From: Daun Johnson [REDACTED]
Sent: 22 February 2019 08:54
To: Sian Eggington
Subject: FW: Further Information Required on Your Ref: PP-07637507 Our Ref: AW/63/19/HH
Attachments: AW_63_19_HH_134359_386745.pdf

Client	Steve King
Job title	31 Elizabeth Avenue Side Extension to Form Self Contained Annexe
Drawing title	Proposed Block Plan / Site Plan

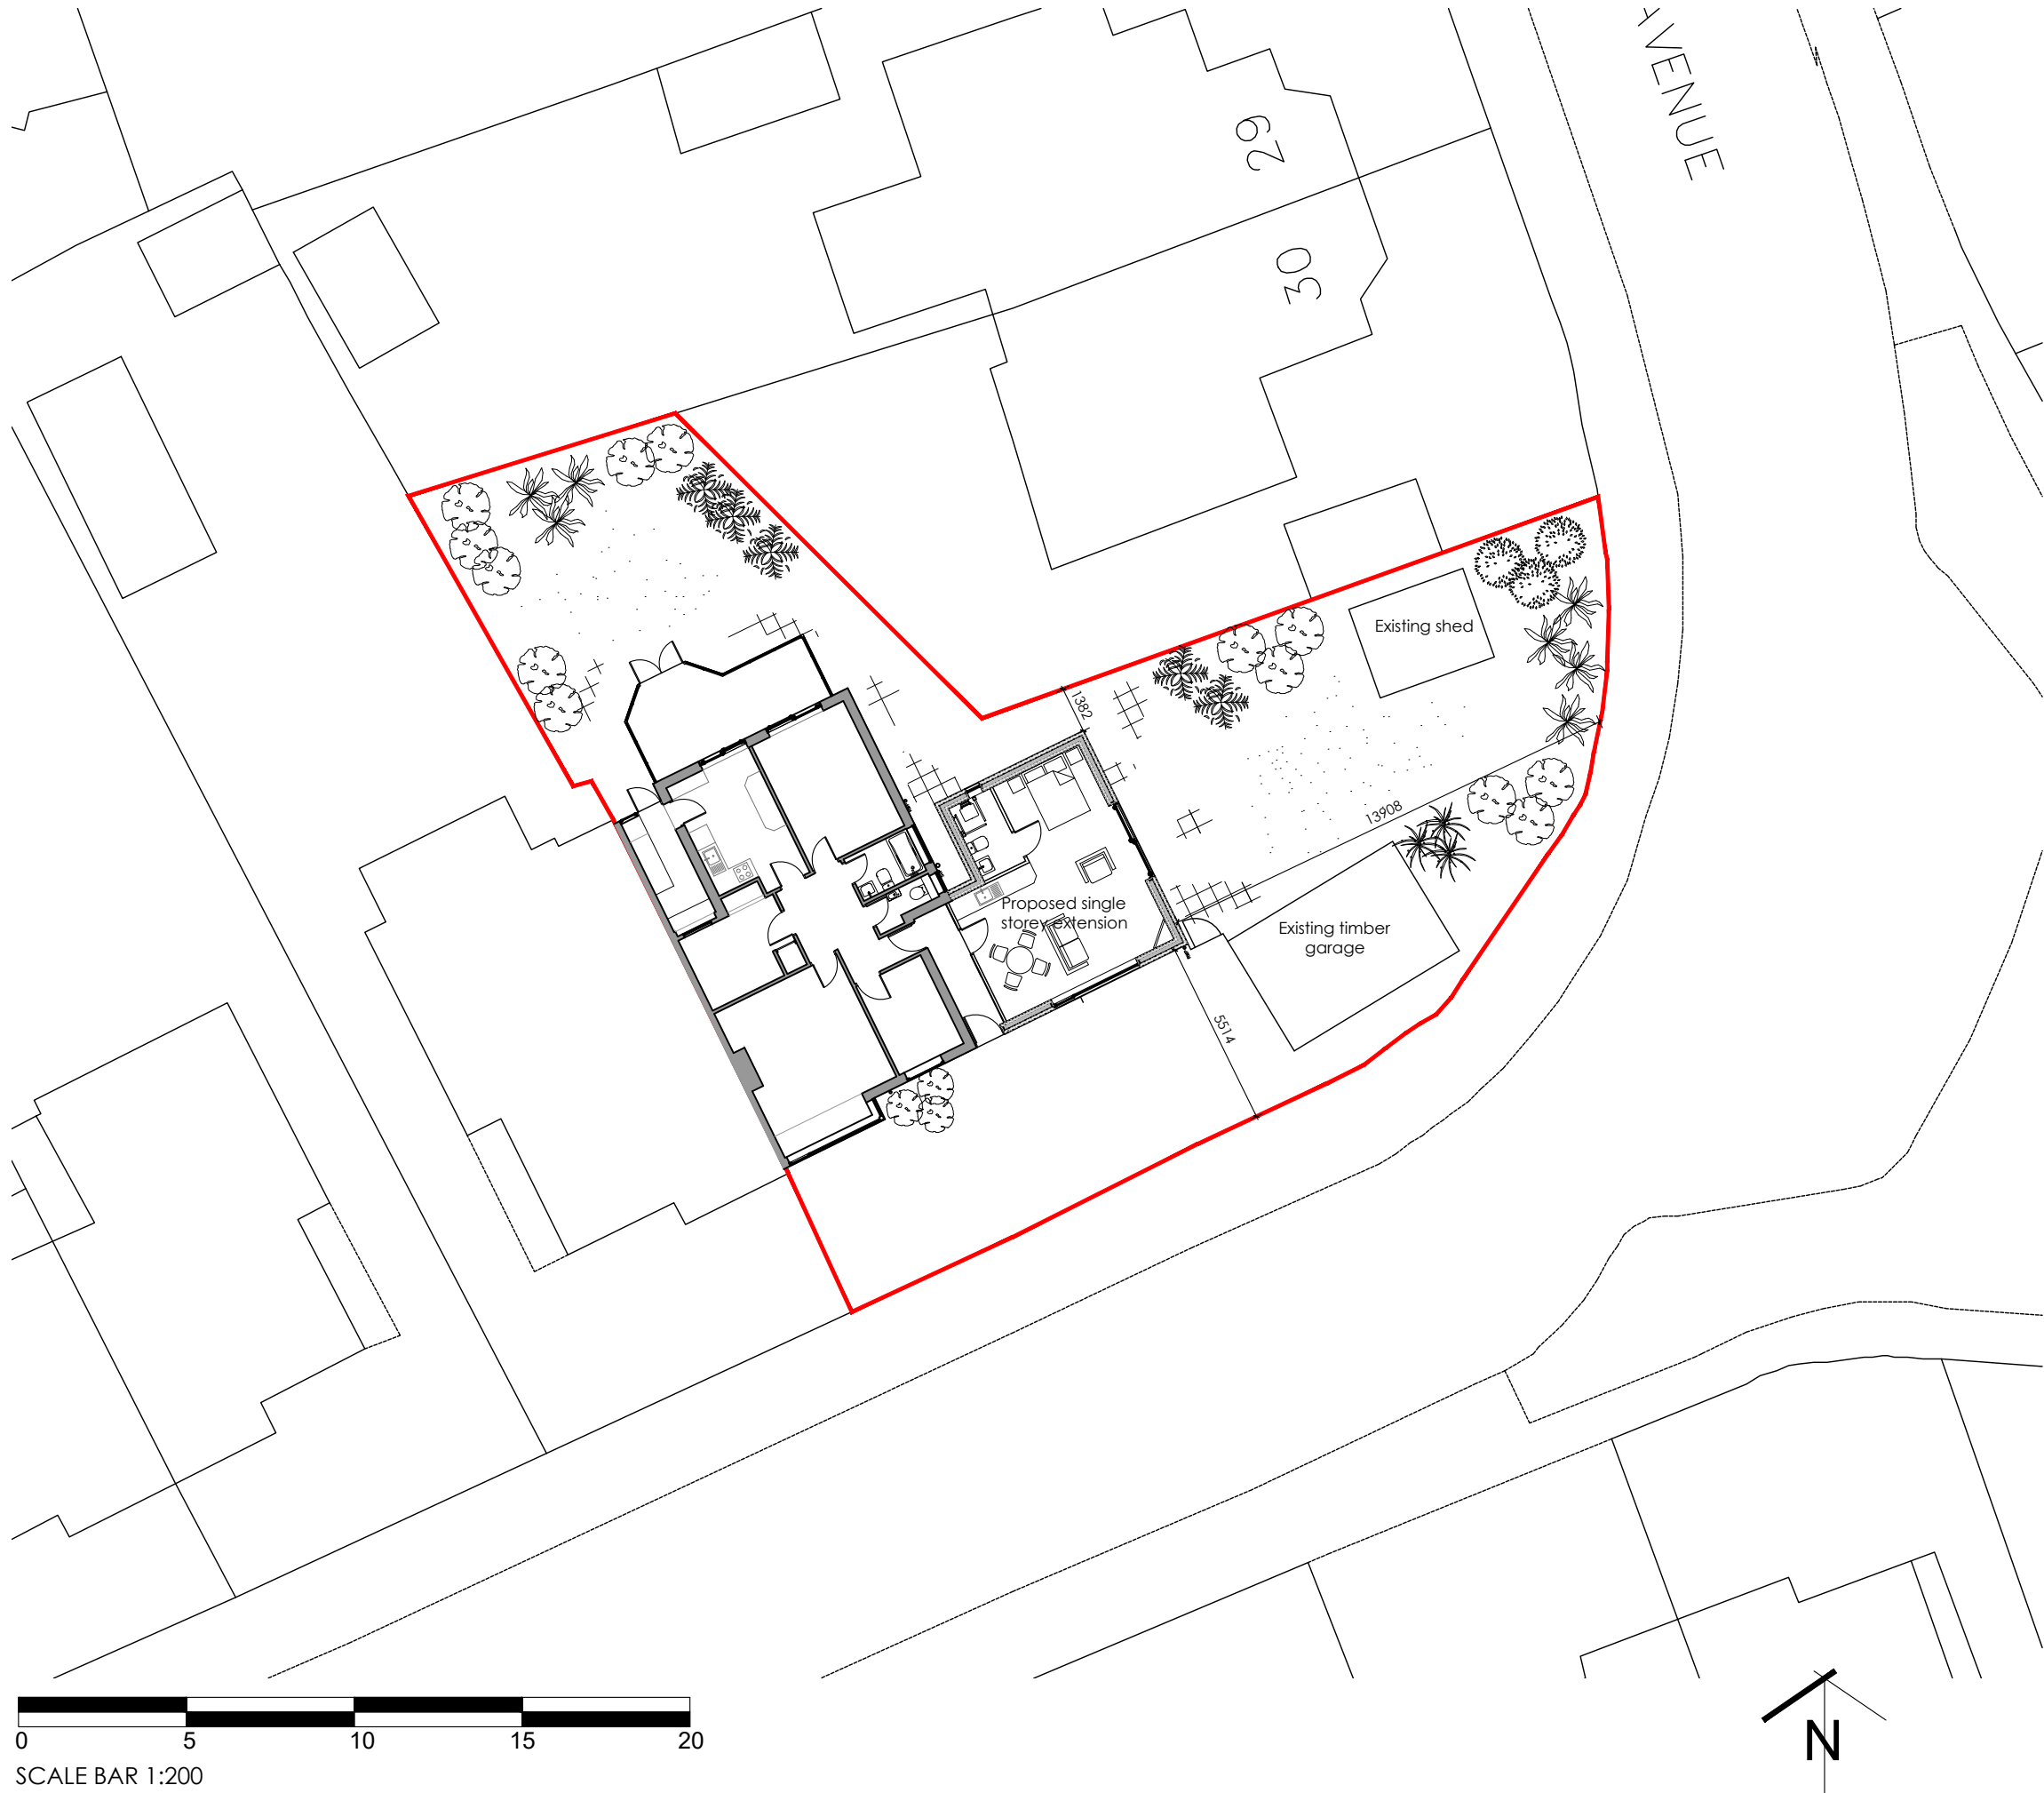
The block plan is included within the submission. It's on drawing number 19.007 -- 30 Rev A. It's at 1:200 as advised on planning portal.
